Our ref: NO/2025/117140/01-L01
Your ref: 3/2025/0873
Date: 28 November 2025

**CONSTRUCTION OF 6 DETACHED DWELLINGS WITH ASSOCIATED PARKING
AND LANDSCAPING AT LAND OFF SPRINGWOOD DRIVE.**

LAND AT SPRINGWOOD DRIVE, WHALLEY, BB7 9XL

**EXISTING SITE PLAN**

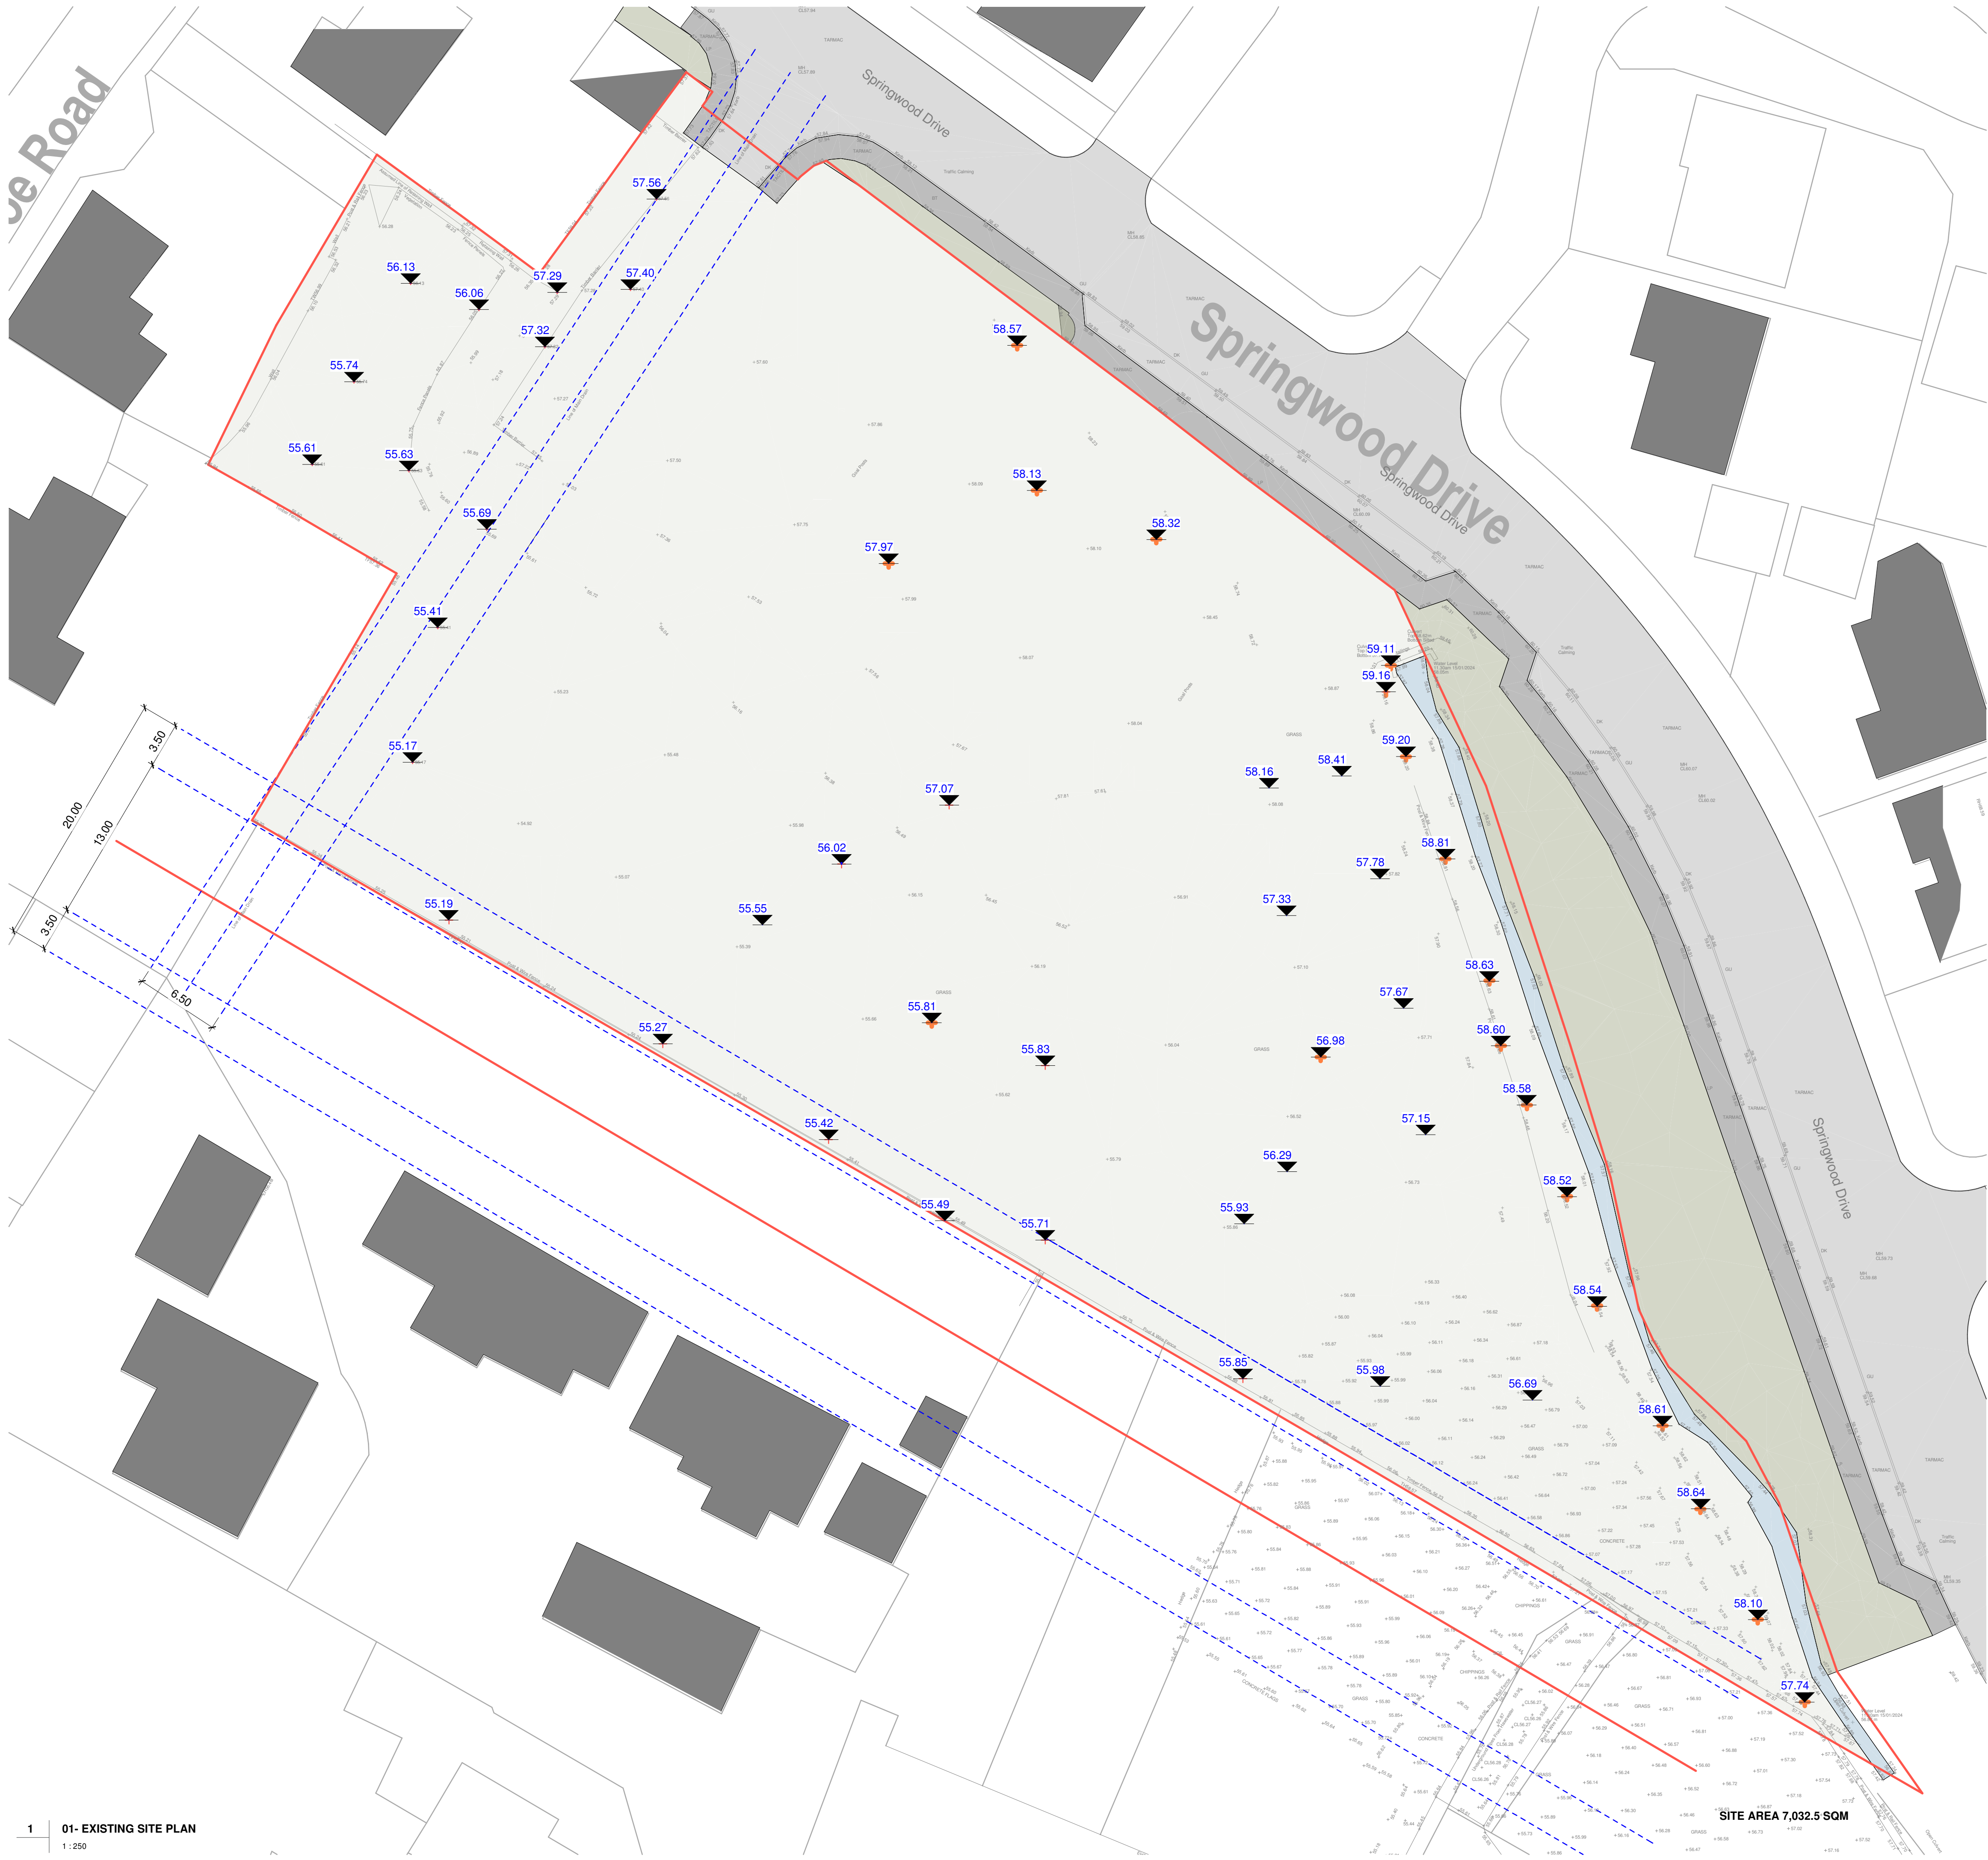
Note: the existing topographical survey in Appendix D is illegible (except for the values that have been superimposed in red/blue) – any superseding survey must be fully legible.

Furthermore, the applicant should provide a pre-development and post-development topographical survey (e.g. using contour lines with 200mm intervals), demonstrating how levels are proposed to change.

12477	SWD-CAA-ZZ-ZZ-D-A-1004	P4
C+A JOB NO.	PROJECT - ORIGINATOR - VOL. - LEVEL - TYPE - ROLE - NUMBER	REV.

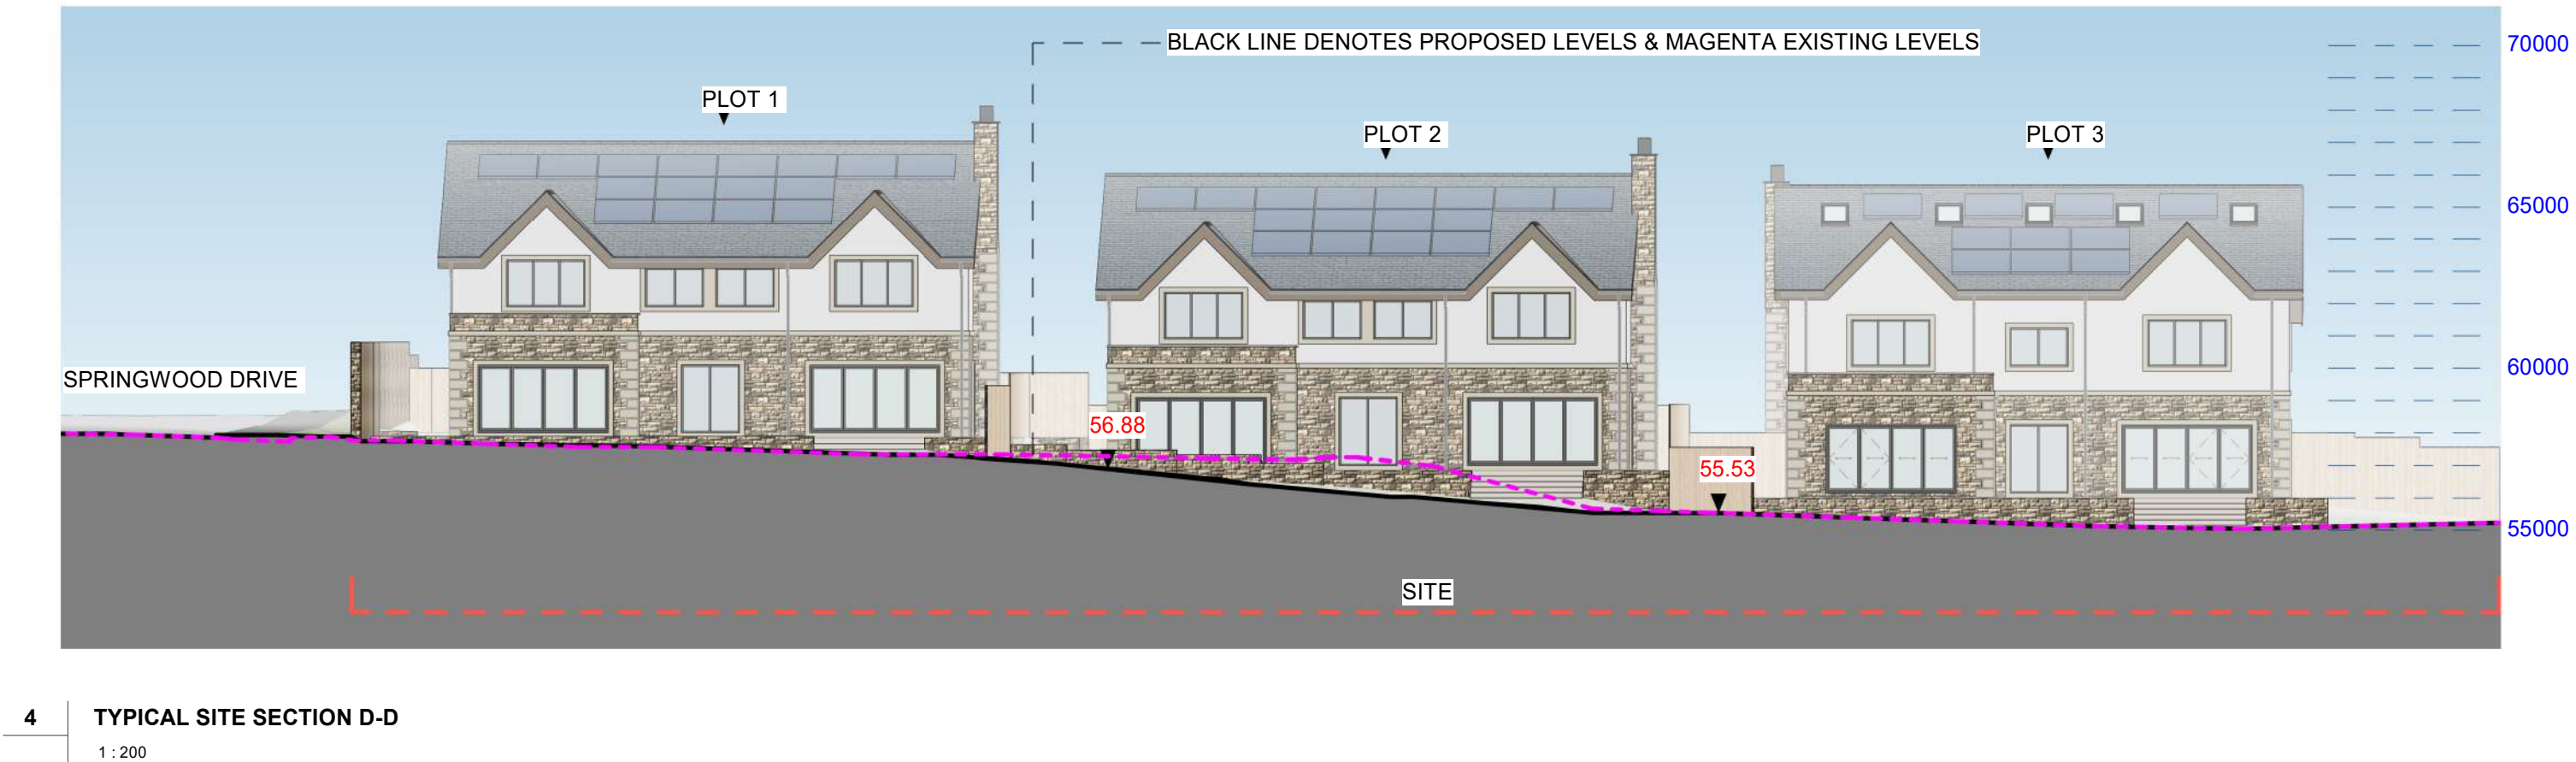
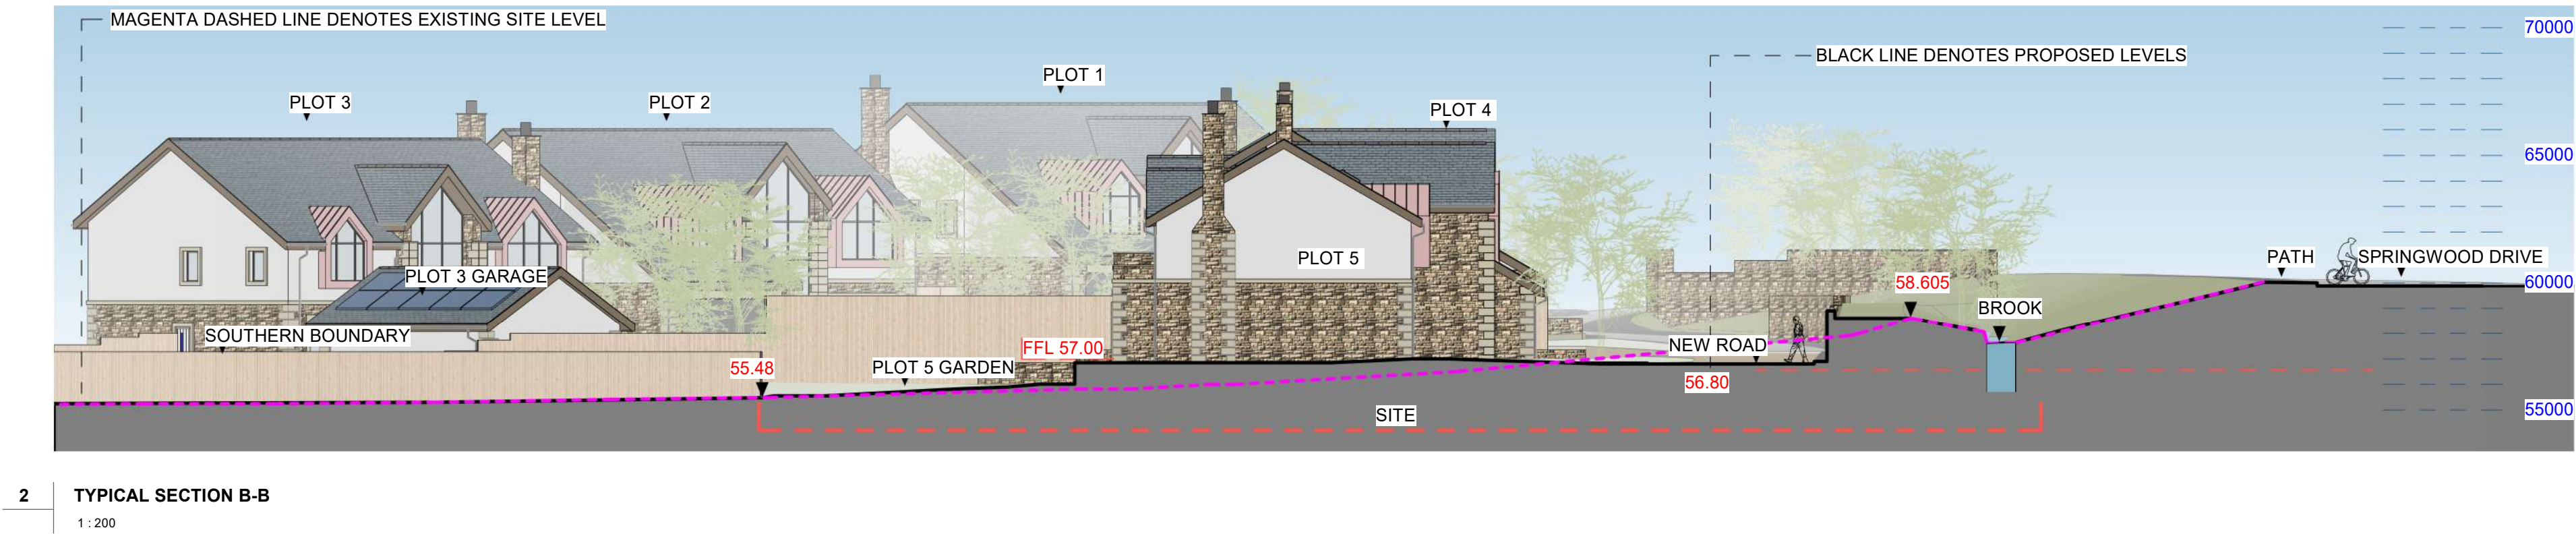
However, Section B-B from drawing No.: SWD-CAA-ZZ-ZZ-D-A-1004 (Rev: P2, Date: 01/10/2025) suggests that levels will be reduced along the western/right bank of Wiswell Brook – this could affect flow routes from the watercourse. Furthermore, the ground level lowering for the “new road” shown in this section could create a new flow route running parallel to the watercourse, which could convey water southwards from any low spot on the brook or following any exceedance/blockage event (ie. From a residual flood risk) on the brook.

The above points raised in this section should all be explored/addressed in an updated FRA.
